From: Kathryn Welch
Sent: 30 November 2020 09:04
To: Planning Scanning
Subject: FW: A/156/20/HH 16 Woodlands Close, Angmering

Due to the second round of consultation for A/156/20/HH 16 Woodlands Close, Angmering; I would be grateful if you would accept an extension of time for the above application until the Thursday 10th of December to allow this to run its course.

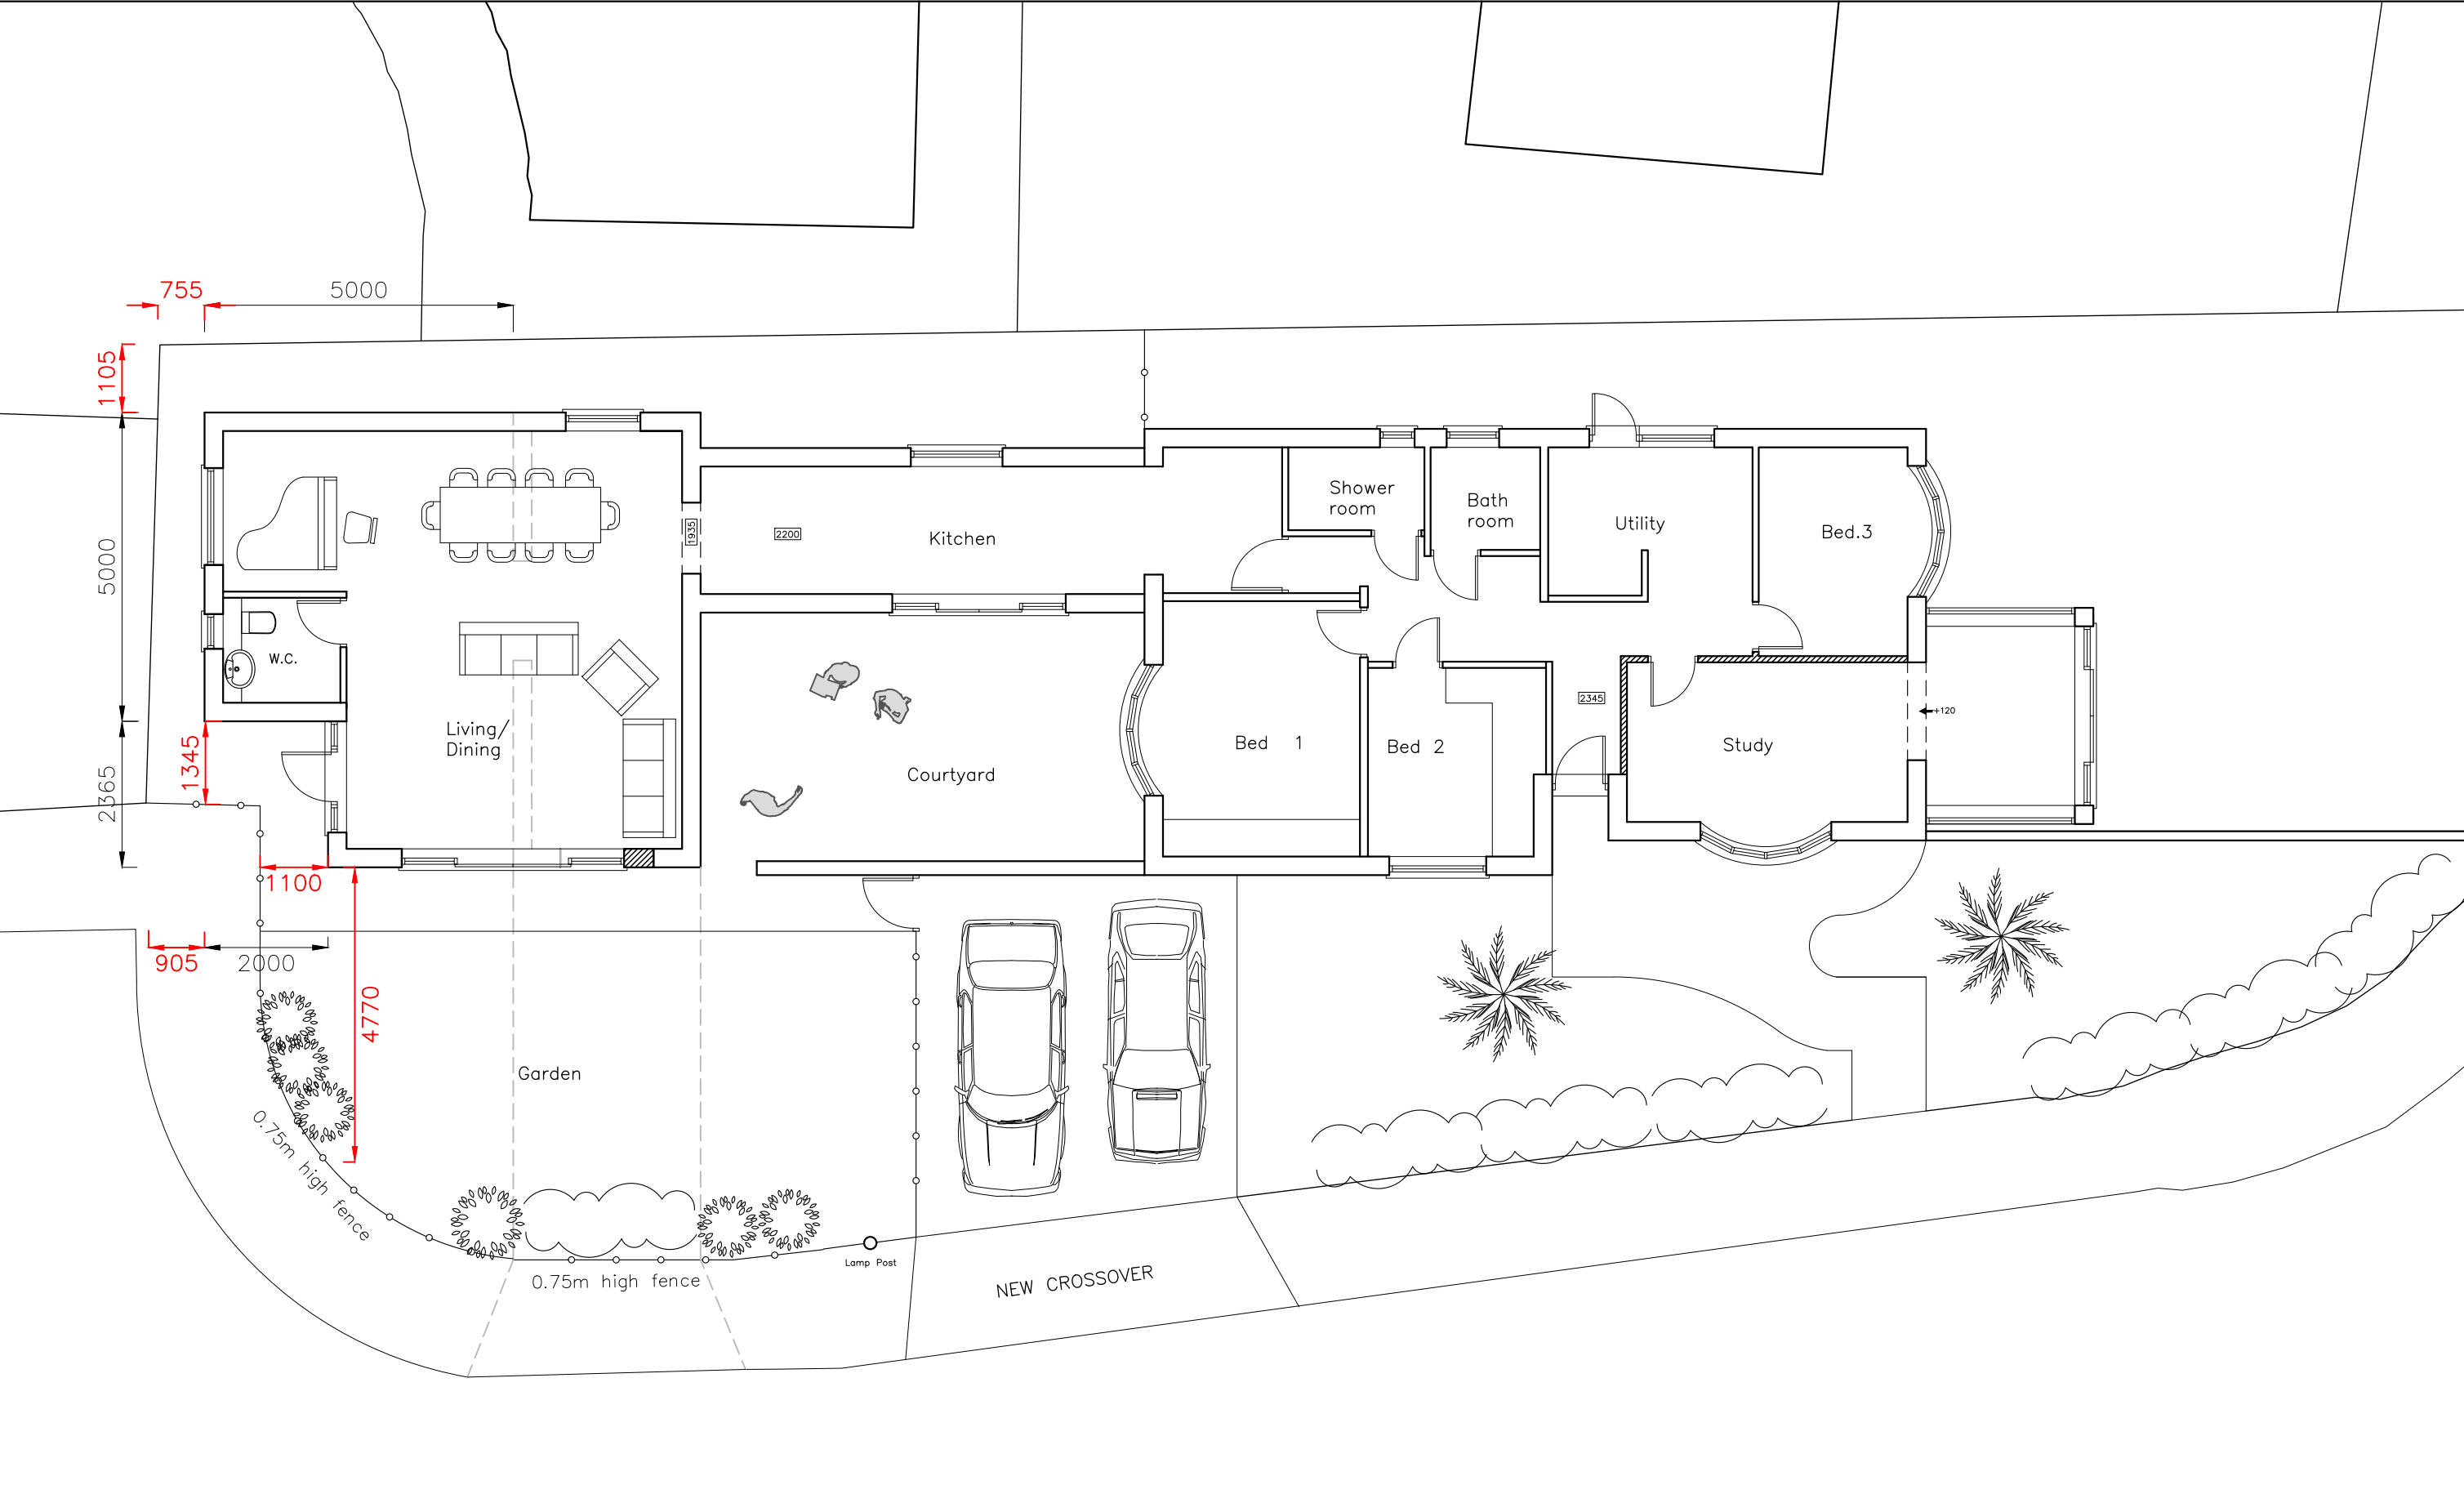
I am writing to you in regards to the above application for which I am now the case officer. Having reviewed the plans and visited the location I am of the view that 1.5m close boarded fence to the front boundary is incongruent within the street scene, which is dominated predominately by low brick walls defining front boundaries to neighbouring properties.

Currently, as the application stands I would be looking to refuse it solely on this point. Therefore should you wish to proceed with the application I would be grateful if you could consider the option of removing the fence from the submission? If this is agreeable to you, could I please obtain amended plans before the 6th of November, in order for me to re-consult the parish before the application deadline. Should you wish to pursue this option but not be able to provide the supplementary plans before this date, I would appreciate if you would agree to withdraw the application with a view to resubmitting the amended scheme in the future.

After consulting with our client, we have reduced the fence height so that the total height including the brick wall is no more than 1m. As our client would be allowed to do this anyway under Permitted Development we feel it is not unreasonable to show it on the drawings. Would you be happy to accept this? Copies of the amended drawings are attached.
